OUT16/23752

**Modification 3 to Syerston Project – Scandium Oxide Modification (DA 374-11-00 MOD 3)
Comment on the Response to Submissions Report**

Modification 3 to Syerston Project – Scandium Oxide Modification (DA 374-11-00 MOD 3) Comment on the Response to Submissions Report Detailed comments – DPI Water

Figure 2: Mine Layout - stage 1

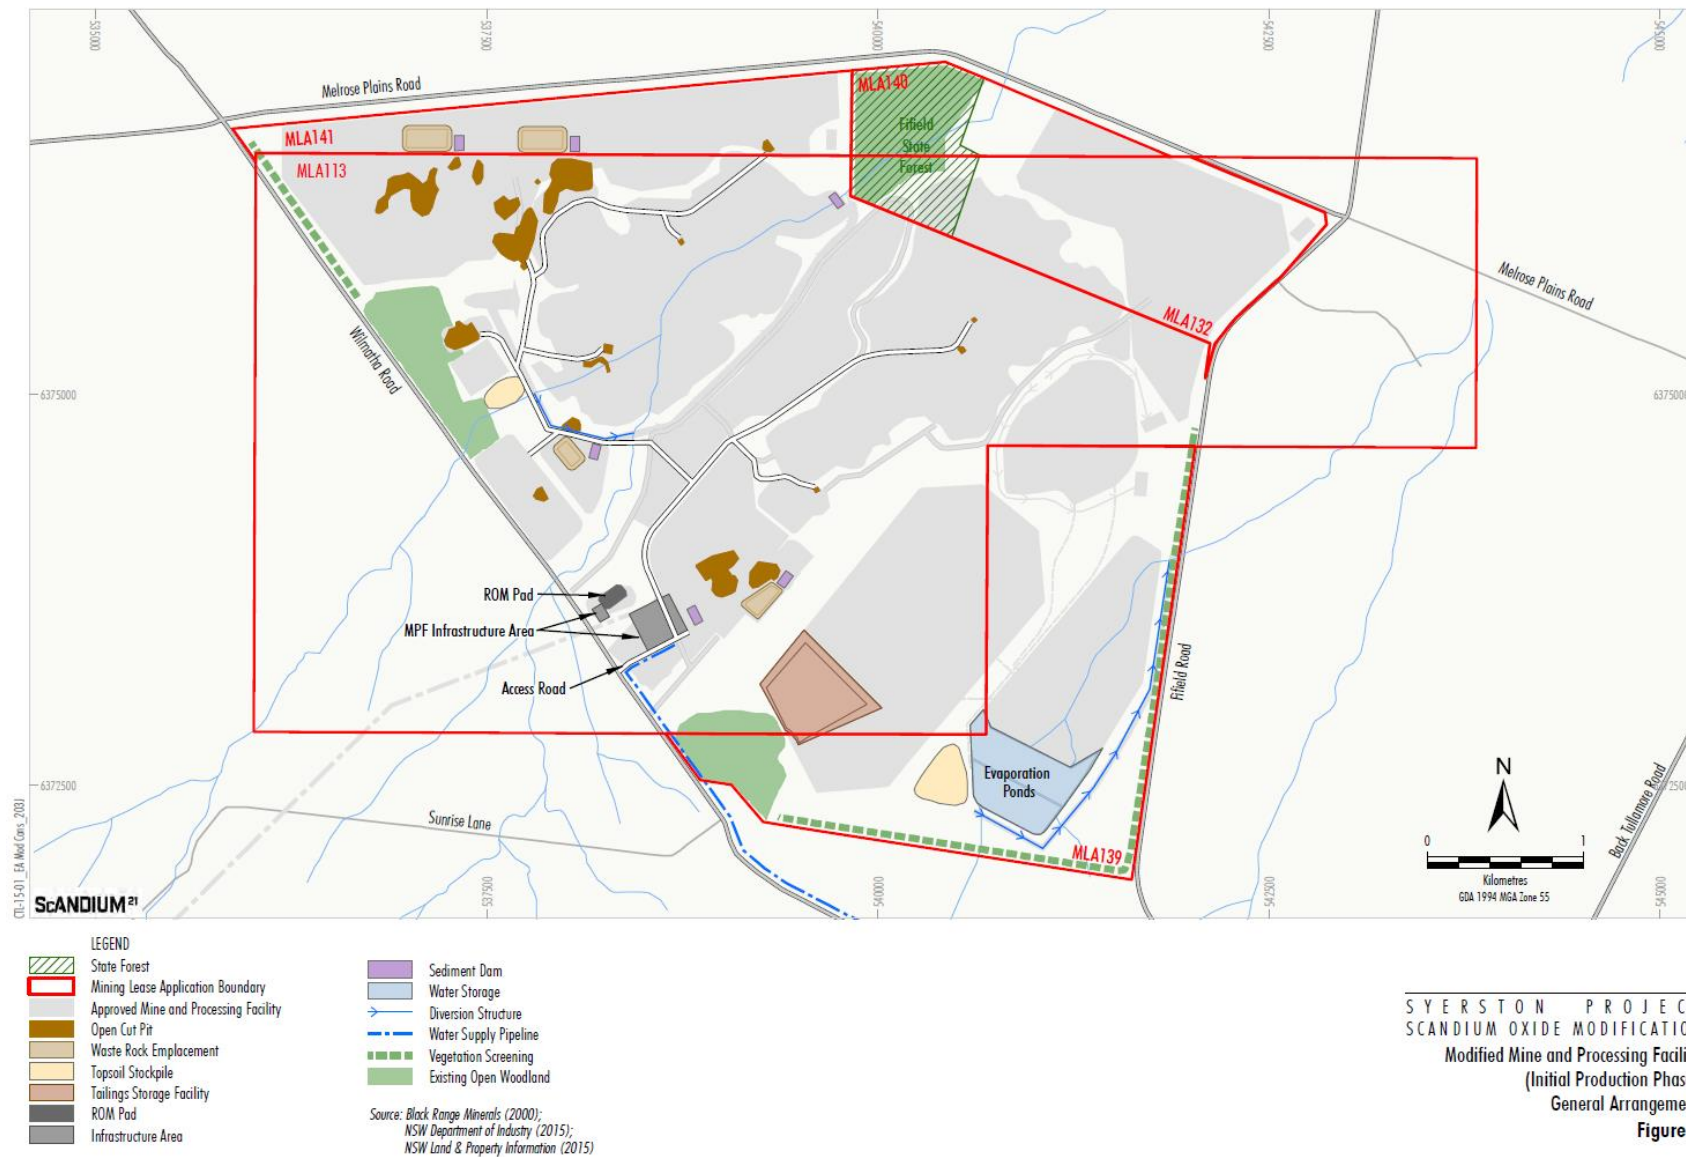
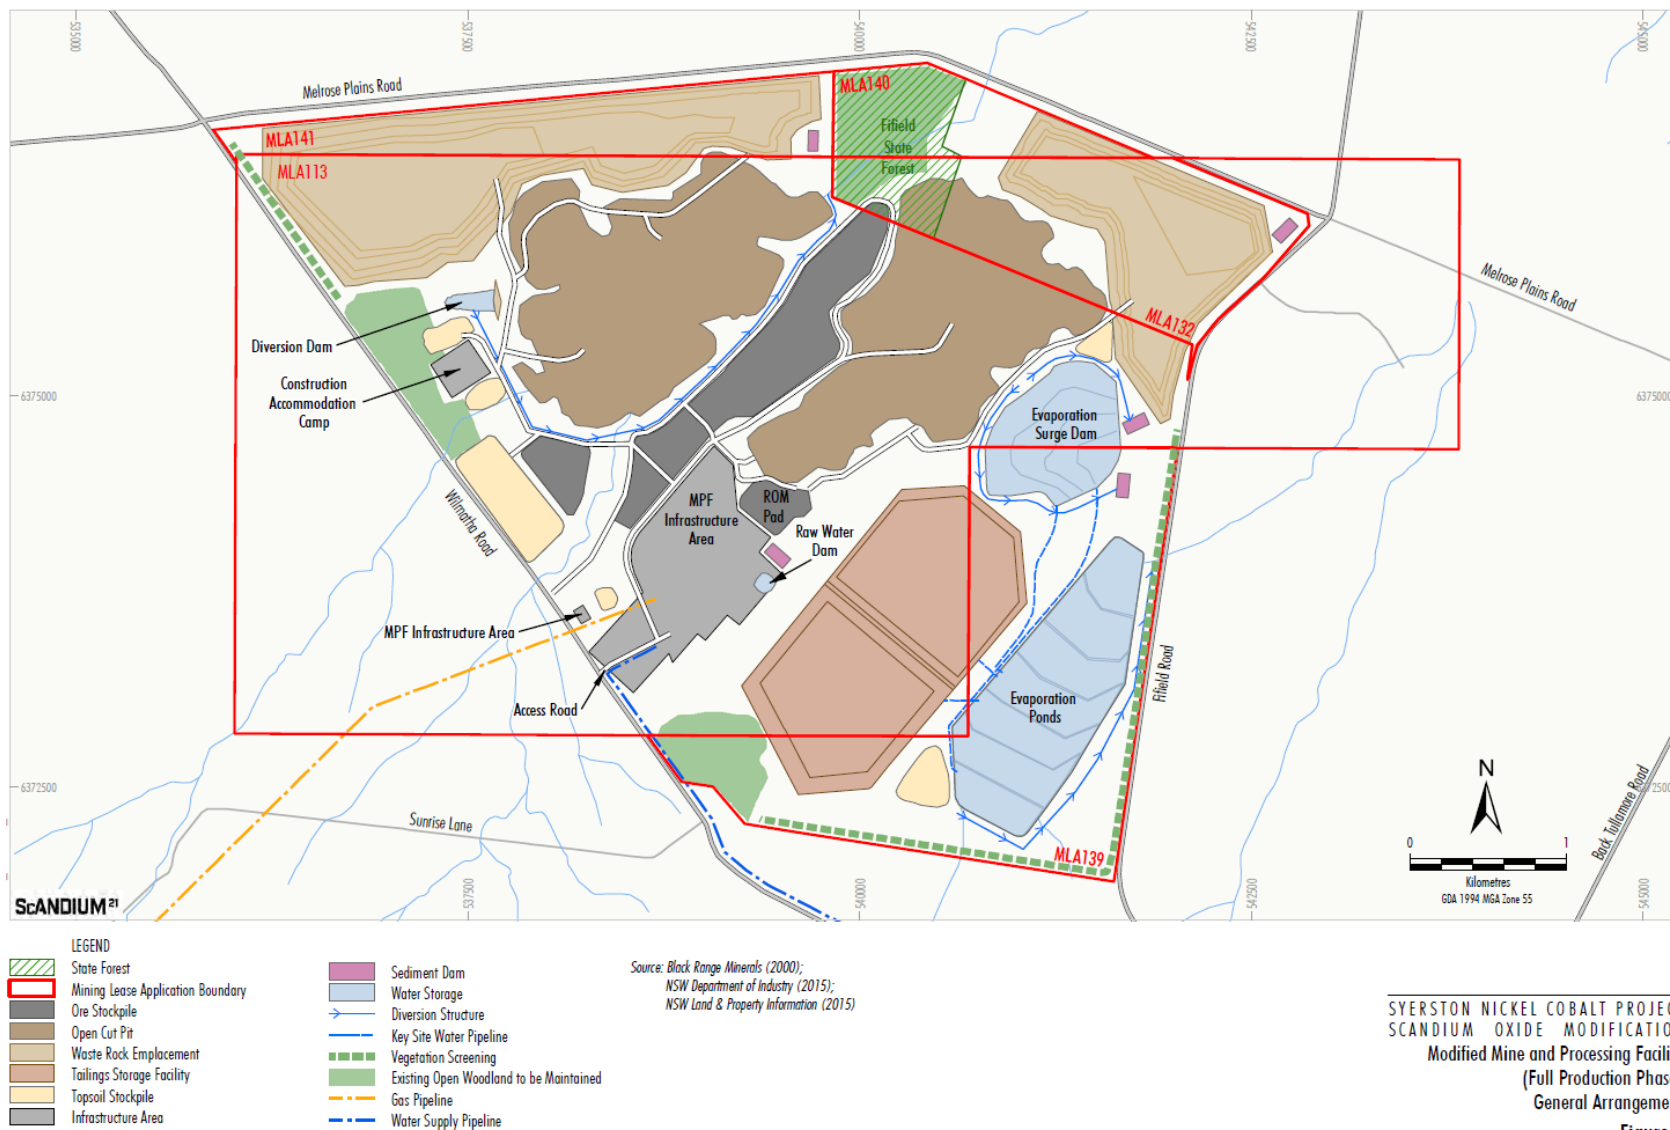
- The RTS has indicated the approved two open cut pits and the small scale pits proposed for this modification will not intersect the local groundwater table. DPI Water is concerned with this description as detail of monitoring bore logs included in the original EIS indicates
-

water was intersected between 33 and 43 m in close proximity to the pits. As the small scale pits are proposed to be 30m deep they may not intersect groundwater, however the larger pits proposed to a depth of 55m would be likely to intersect groundwater. A hydrogeological assessment of inflows will be required to quantify the inflows and associated impacts to water users and the aquifer both during mining and for any ongoing take once mining ceases and an equilibrium is reached. A groundwater monitoring, mitigation and contingency plan as part of a Groundwater Management Plan is recommended to understand and manage groundwater impacts in relation to the open cut pits.

- The proponent will be required to hold sufficient entitlement to account for any water take in the open cut pits prior to this take occurring. This entitlement will need to be held in the Lachlan Fold Belt groundwater source of the Water Sharing Plan for the NSW Murray Darling Basin Fractured Rock Groundwater Sources. It is recommended a commitment and process to obtain this entitlement be detailed within a Water Management Plan.

1. The proponent prepares a Water Management Plan in consultation with DPI Water prior to commencement of activities. This is to address the site water balance, water demands and sources, water metering and monitoring, borefield management, open cut pit groundwater interception and impact management, sediment and erosion control, pipeline installation and watercourse diversions.

Figure 6: Borefields Layout

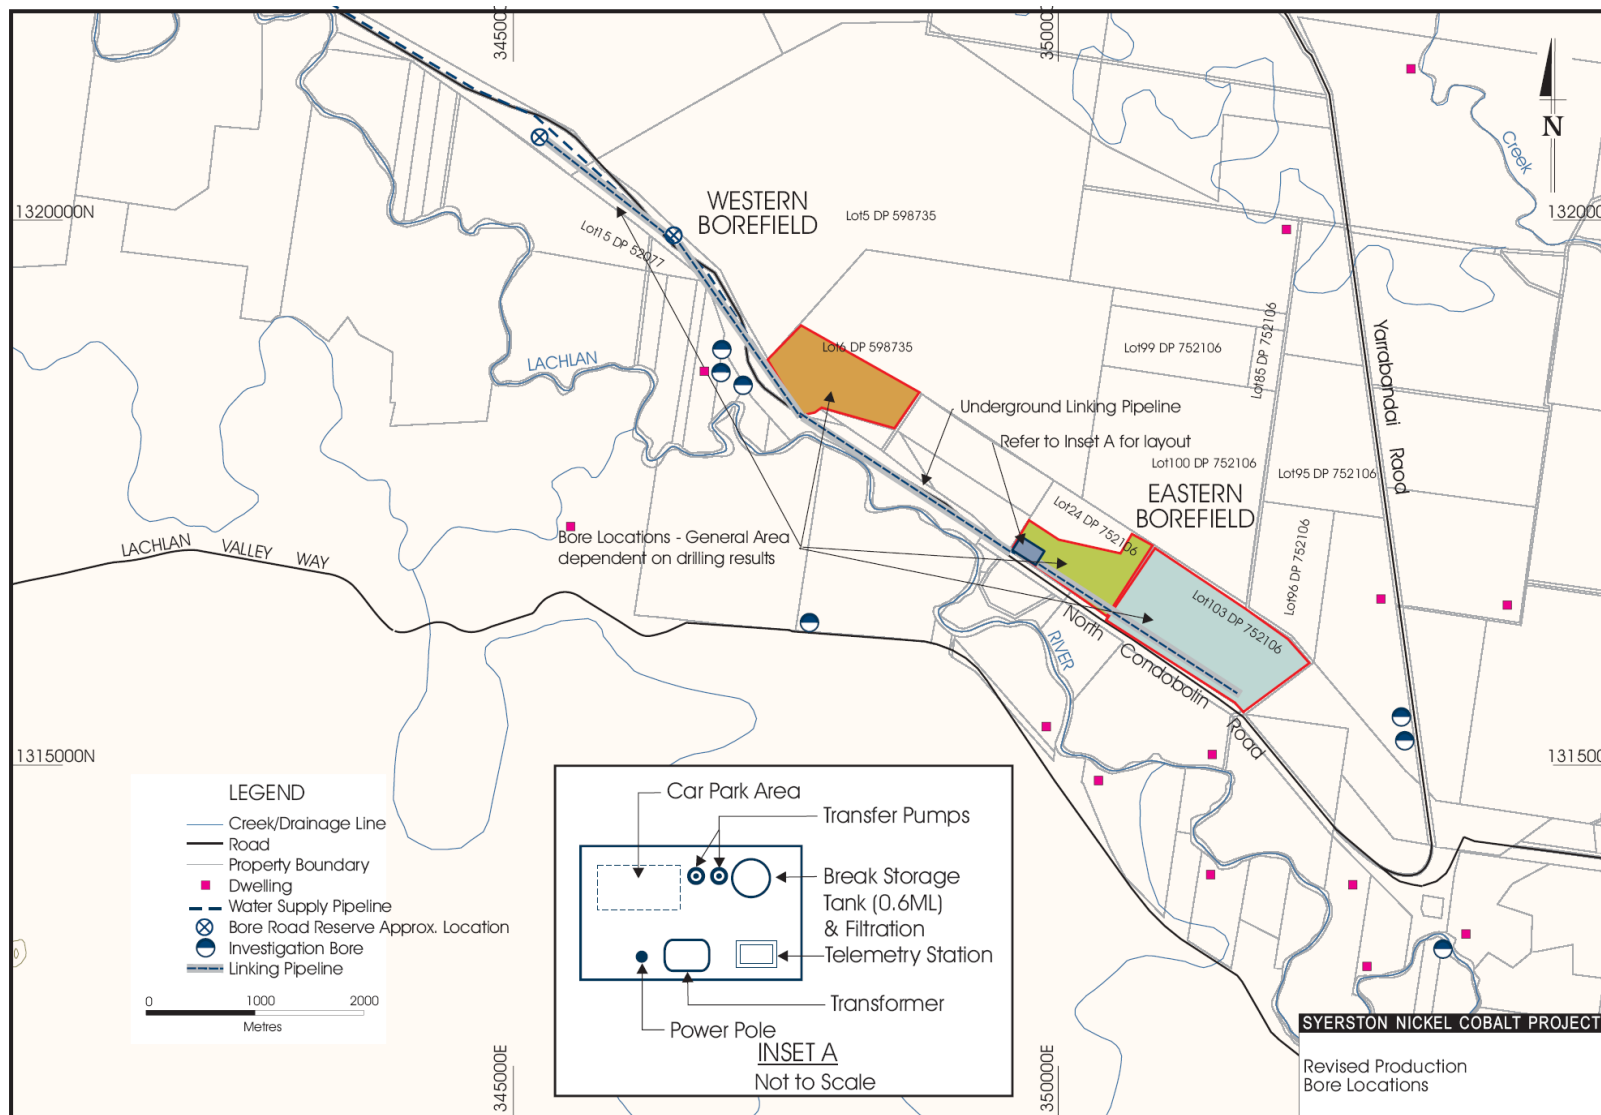
- As outlined by the Coffey Geosciences (2000) report titled 'Water Supply Borefield – Hydrogeological Investigation' the water level drawdown impact to shallow bores installed in the Cowra Formation is likely to be variable. The 'Model 1' simulation which does not factor adjacent Lachlan River leakage predicted that bores adjacent to the borefield installed to depths of less than 30 m below ground could fail ("dry up"). In order to address this Scandium21 Pty Ltd (Scandium) included in the RTS that there would be an inclusion of amelioration measures for potentially impacted groundwater users in the Borefield Impact Management Plan (BIMP). The development of the BIMP prior to commencement of operations is supported by DPI Water.

- The BIMP will be required to consider impacts to bores assessed during the original assessment in 2000 and any additional bores installed since that date. It will need to recognise that management of impacts by way of make good provisions may include measures such as replacing and equipping impacted bores OR where appropriate provide direct supply (e.g. via pipeline) of water to impacted bore users. Instances where requirement for direct supply may include where the available water bearing alluvium has been dewatered or where pumping due to local drawdown becomes cost prohibitive.
